site development plan.pdf Markup Summary

Subject: Callout
Page Label: [1] 1 COVER SHEET
Lock: Unlocked
Status:
Checkmark: Unchecked
Author: dsdlaforce
Date: 4/23/2018 6:18:53 PM
Color: ■
Layer:
Space:

SITE PLAN

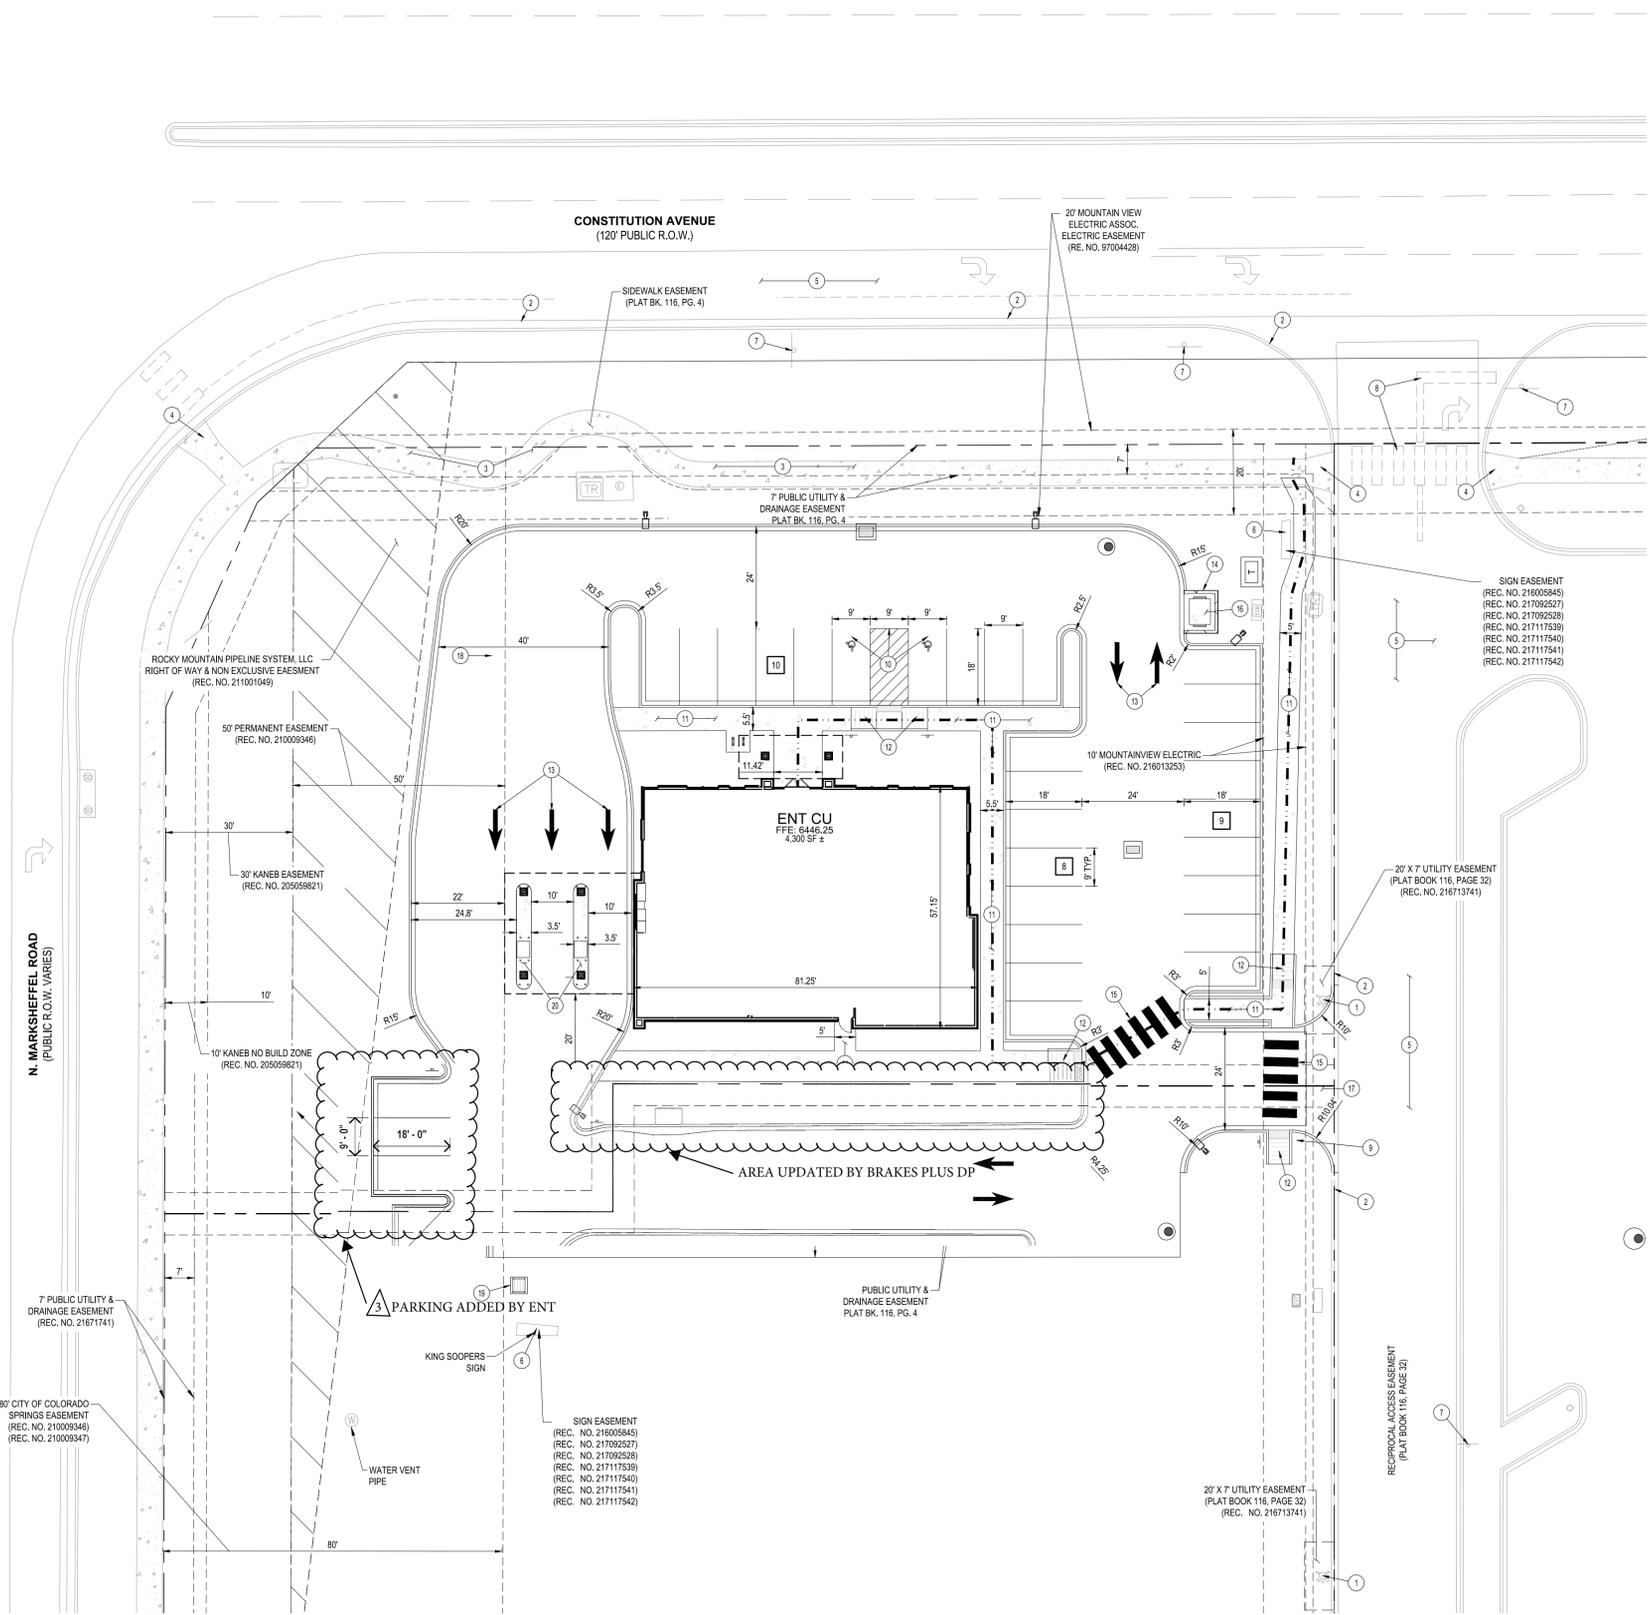
update callout to 11

Show dimensions of the structure

what is this?

Show width of drive thru, must be 8'.

SITE DETAILS

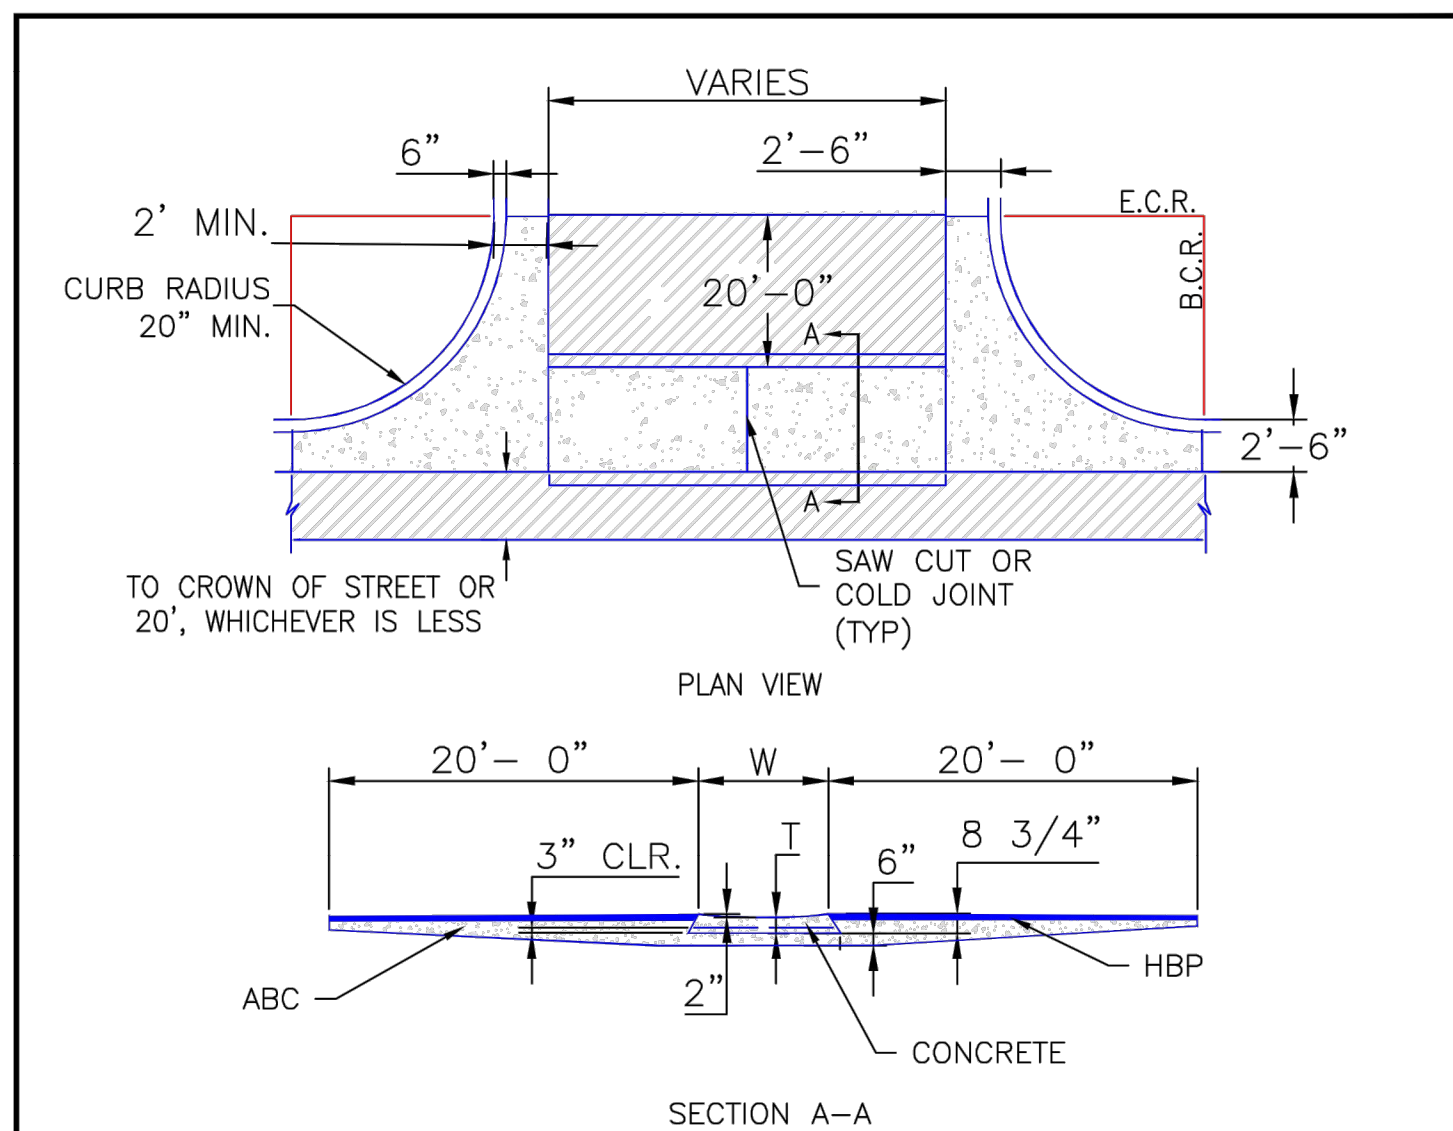
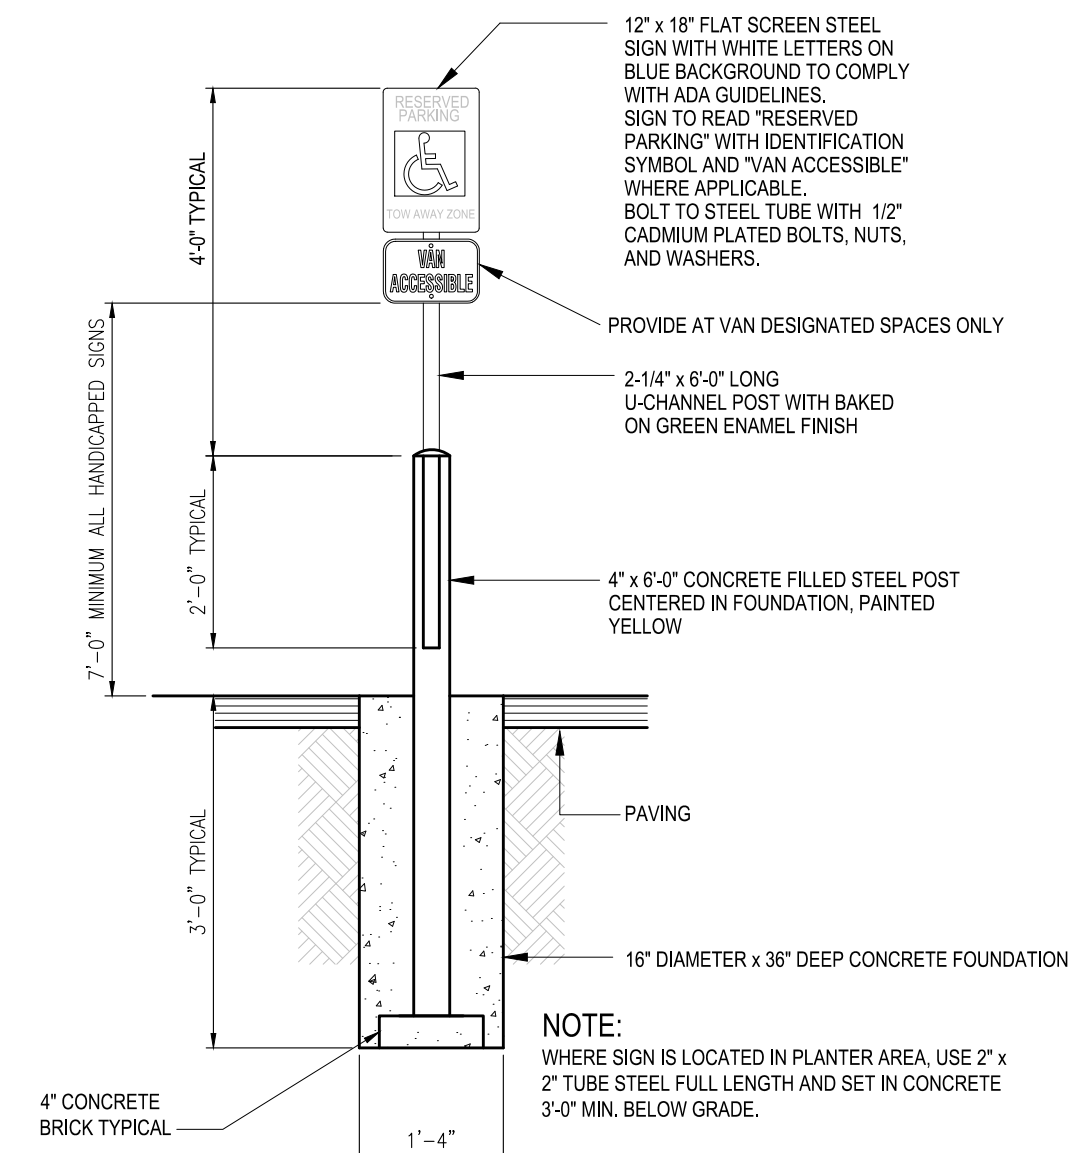
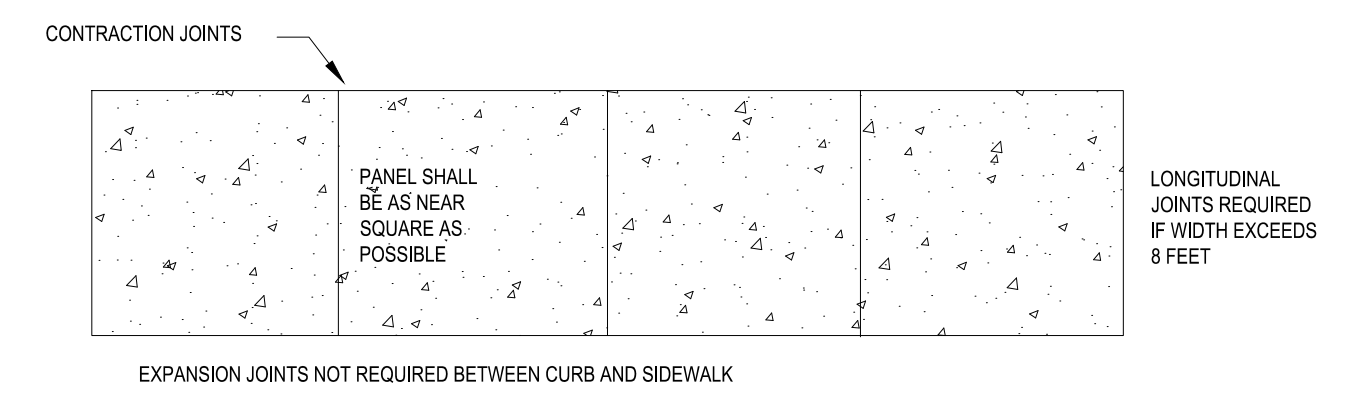
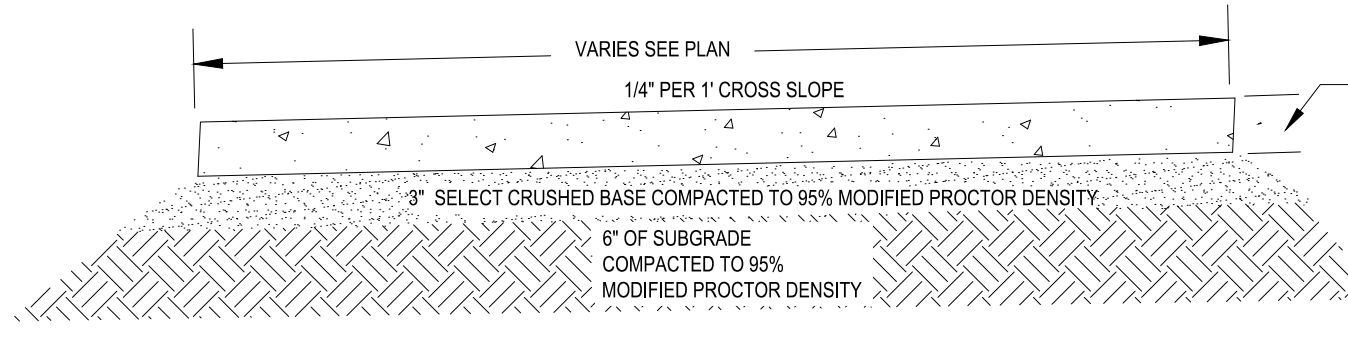
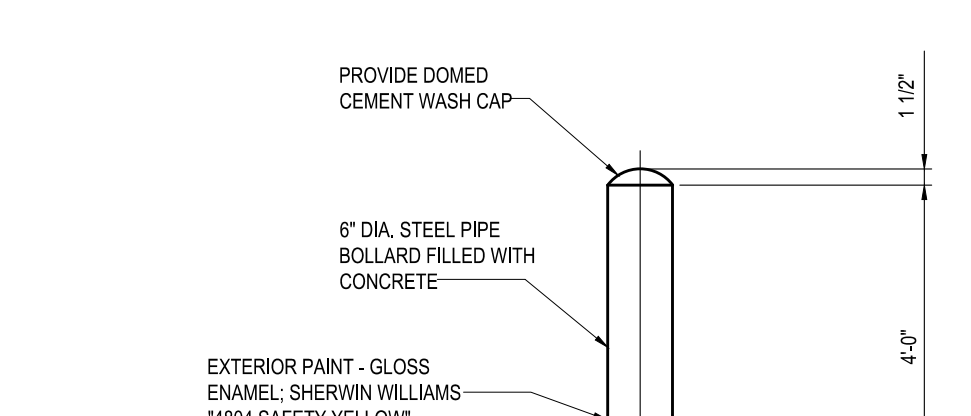
Revise.
Typical convention is horizontal:vertical

PHOTOMETRIC PLAN

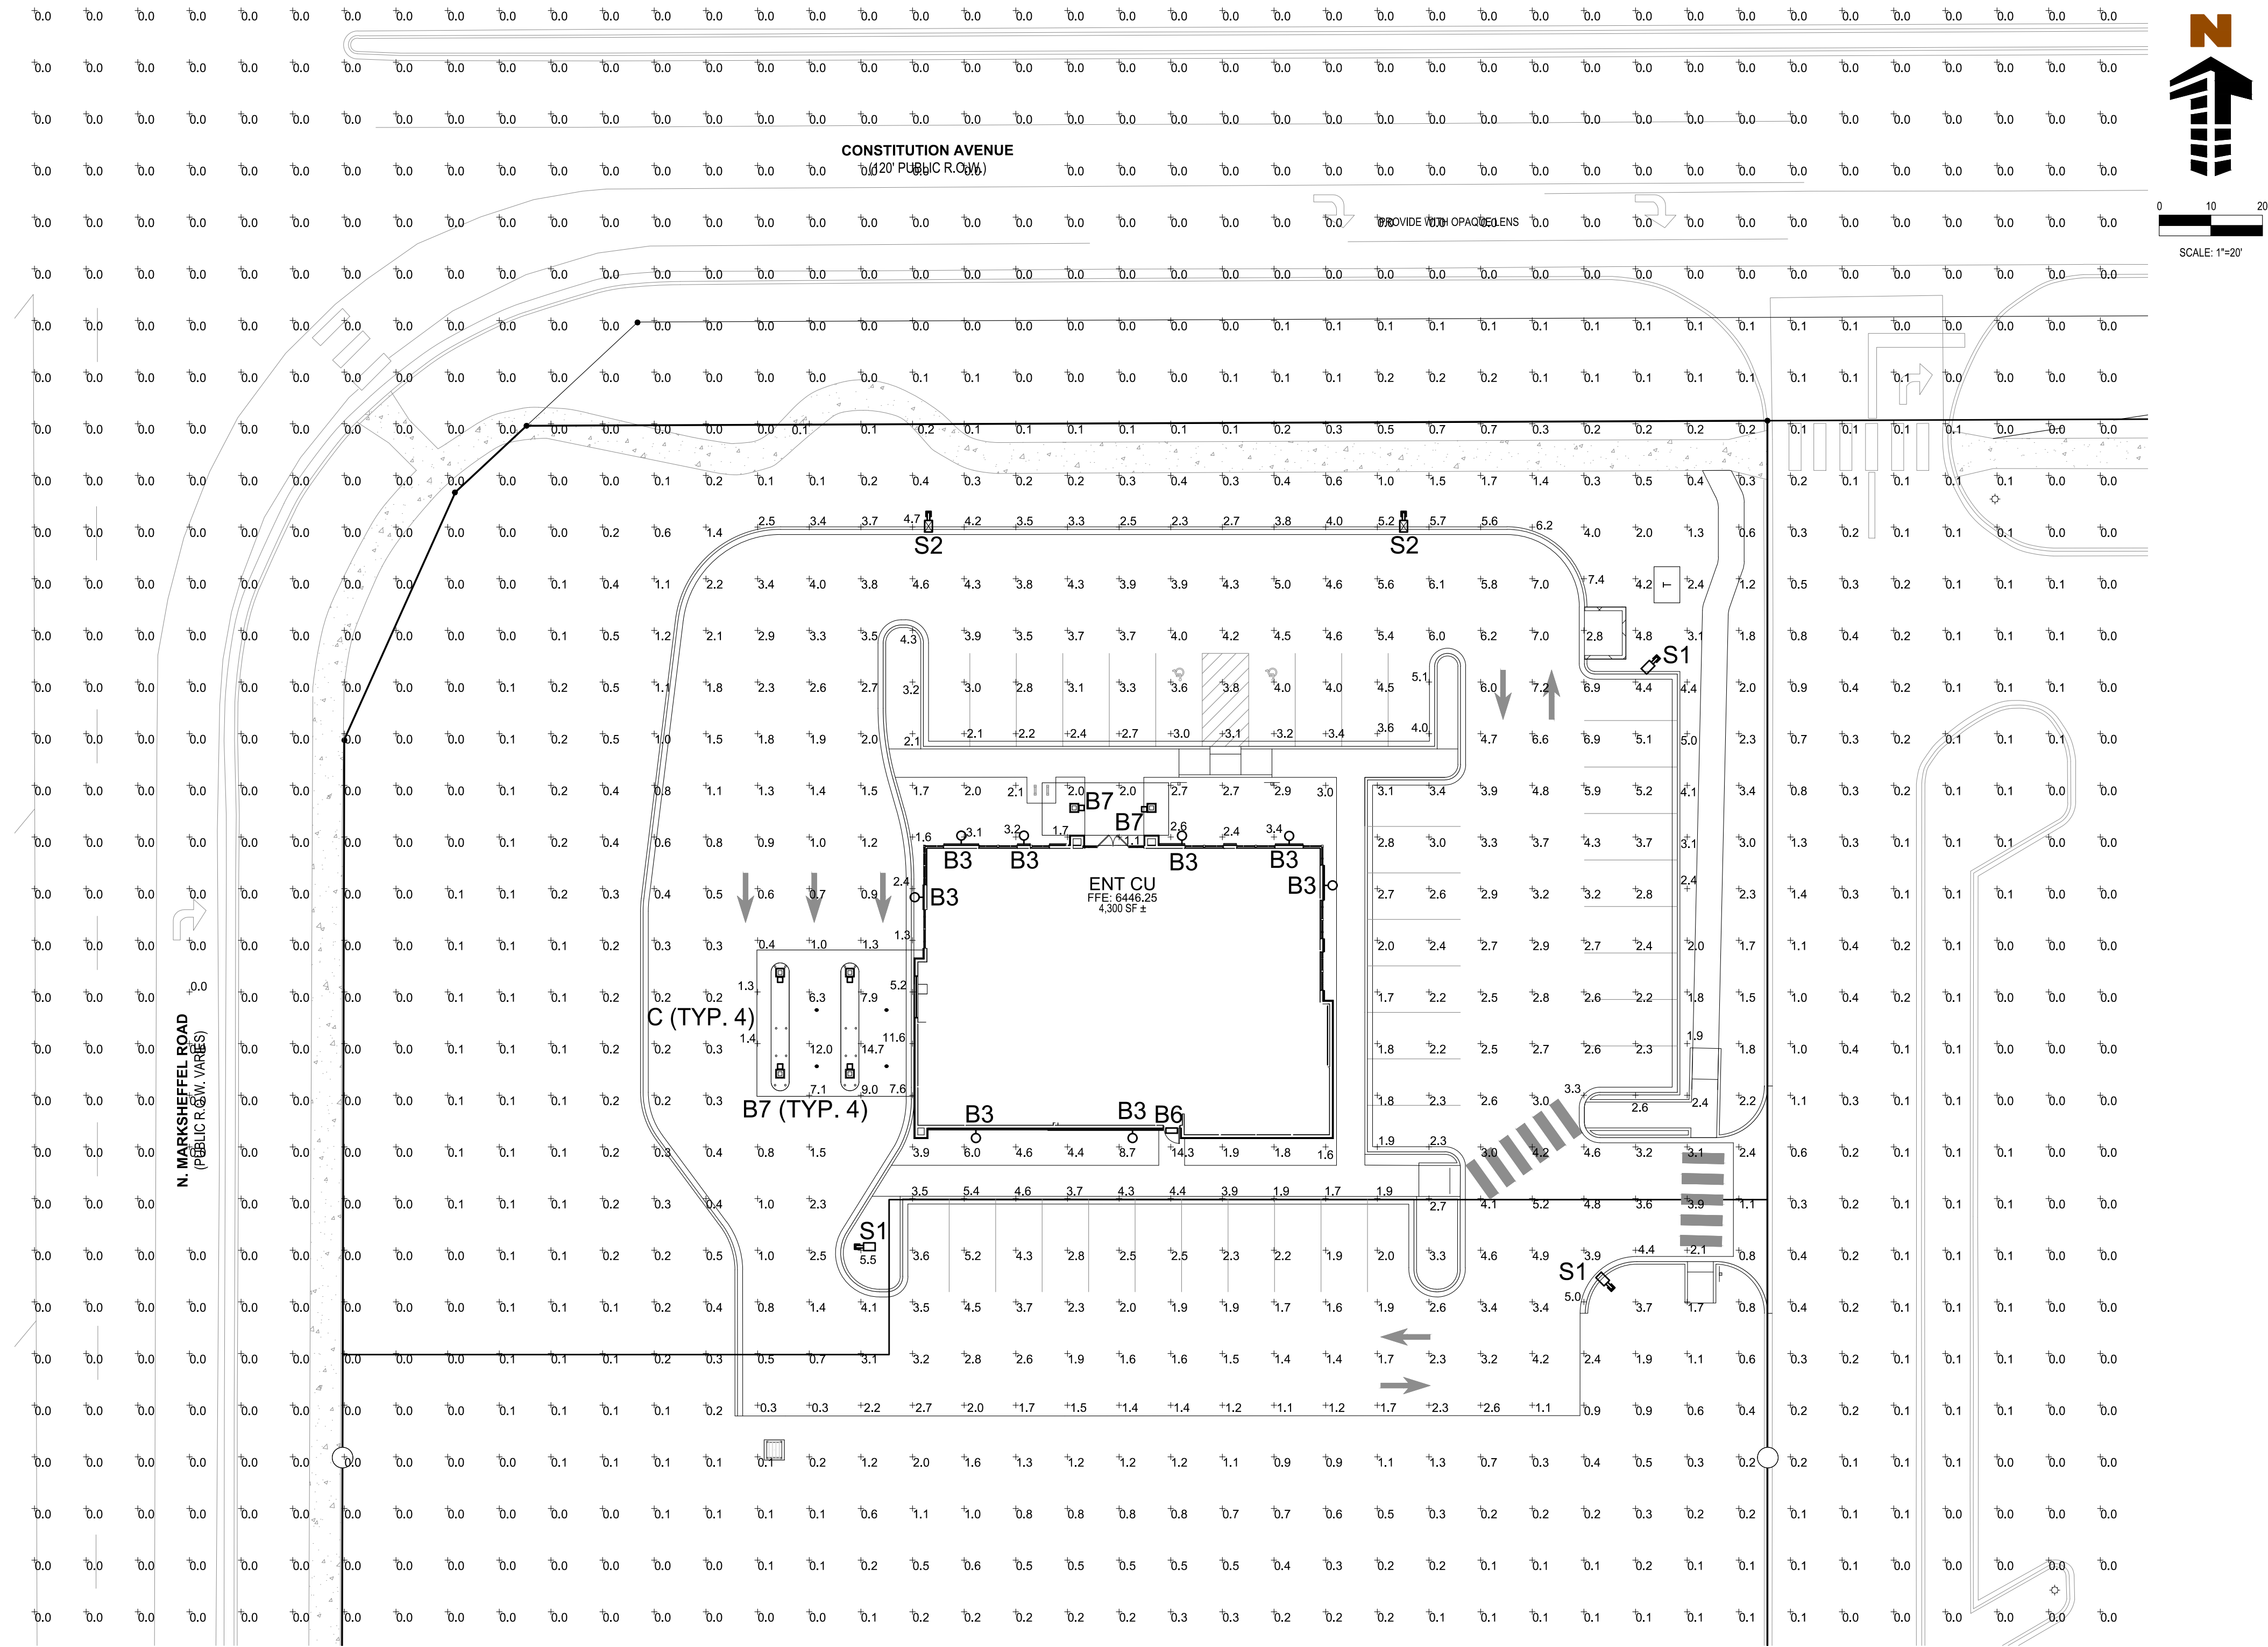
Poles can be no taller than 15 feet unless they are parking lot fixtures, then 20 feet is allowed.
